Application Ref:	2025/0138			 Ribble Valley Borough Council <hr/> www.ribblevalley.gov.uk
Date Inspected:	29/04/2025	Site Notice:	13/03/2025	
Officer:	EP			
DELEGATED ITEM FILE REPORT:				APPROVAL

Development Description:	Proposed erection of an oak framed entrance porch to the west elevation.
Site Address/Location:	2 Spread Eagle Barn, Clitheroe Road, Whalley BB7 9AQ.

PROPOSED WEST ELEVATION  
Scale 1:100

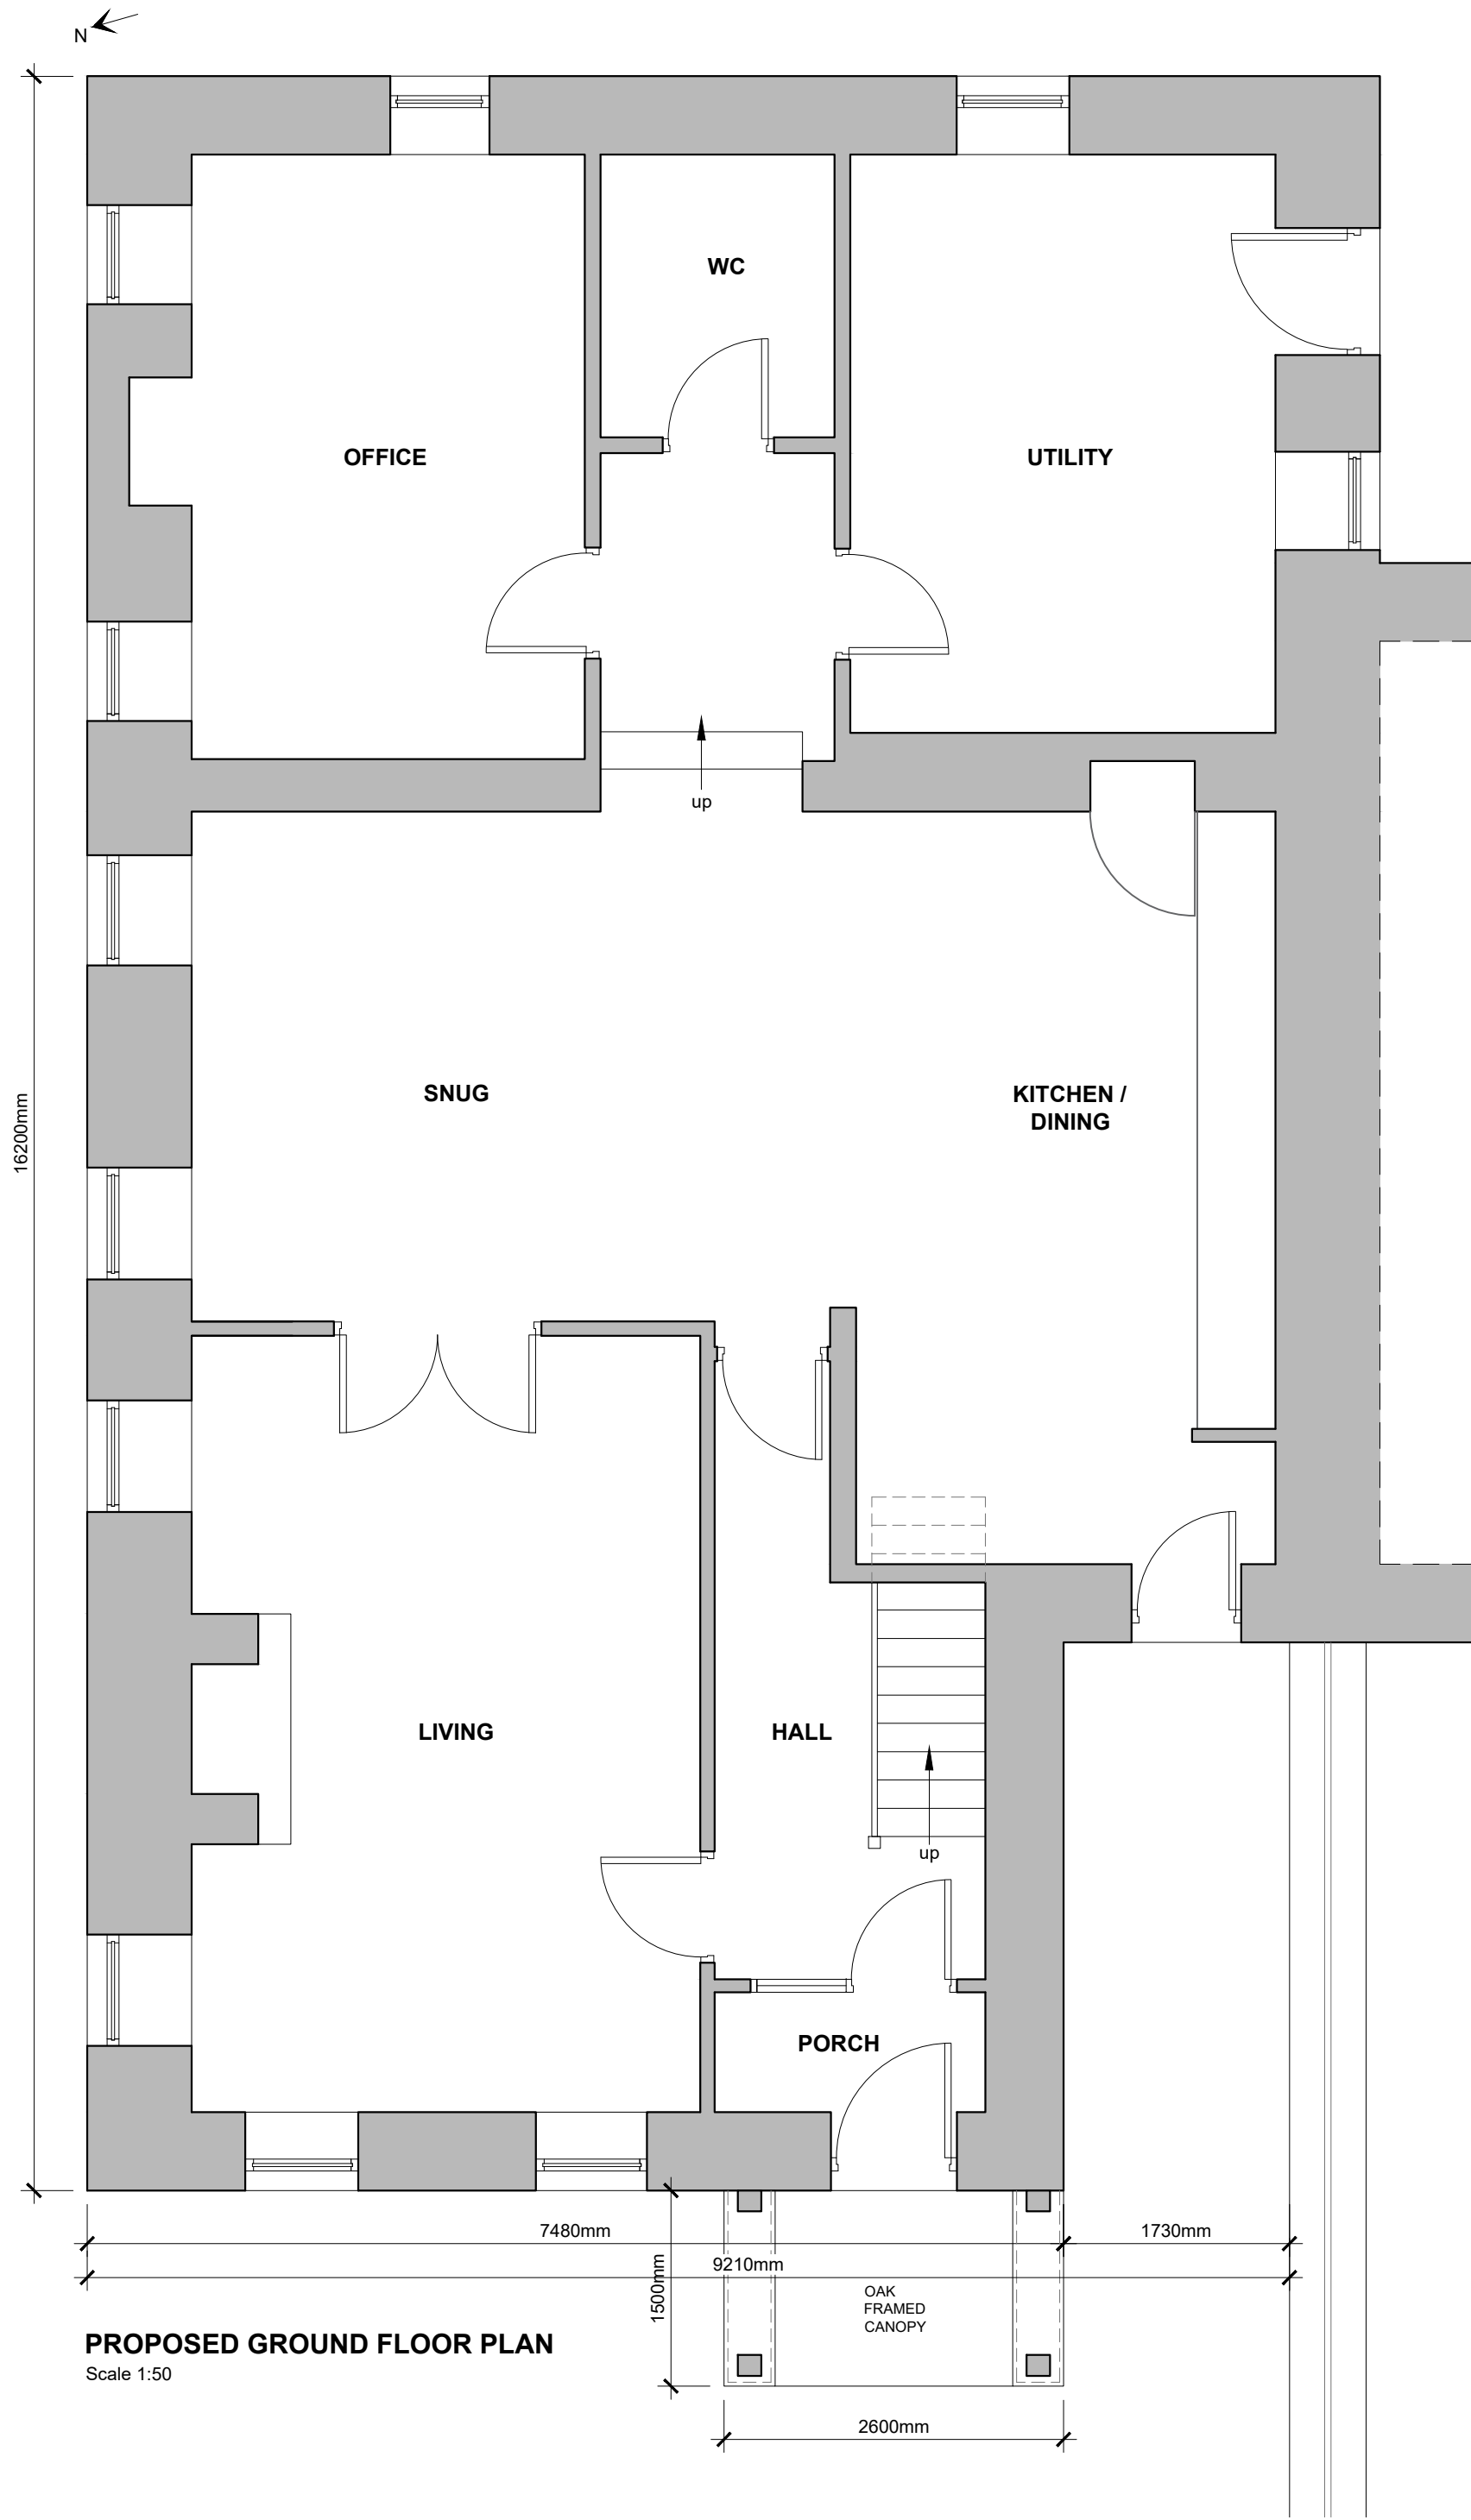
The original submission included the construction of a Juliet balcony at first floor level on the principal elevation of the property. This resulted in large section of glazing being introduced. At present, there is a strong sense of uniformity amongst the fenestrations of the application property and its adjoining neighbour (the other half of the barn). All window openings at present are consistent in size, with the exception of the original barn cart door. It was therefore concluded that the construction of this large section of glazing at first floor, particularly given its visual prominence, would undermine the character of the barn conversion. Following discussion, this element was subsequently removed.

The application now seeks consent only for the introduction of an oak porch canopy. In respect of scale, the porch is modest projecting just 1.5m from the elevation of the dwelling and having a maximum height of 3.4m to the ridge. The proposal is proportionate to the dwelling. In regard to materials, the porch will be constructed using a small amount of natural stonework to the base, an oak frame and slat roof. This choice of natural materials is appropriate to the barn conversion and will integrate sufficiently.
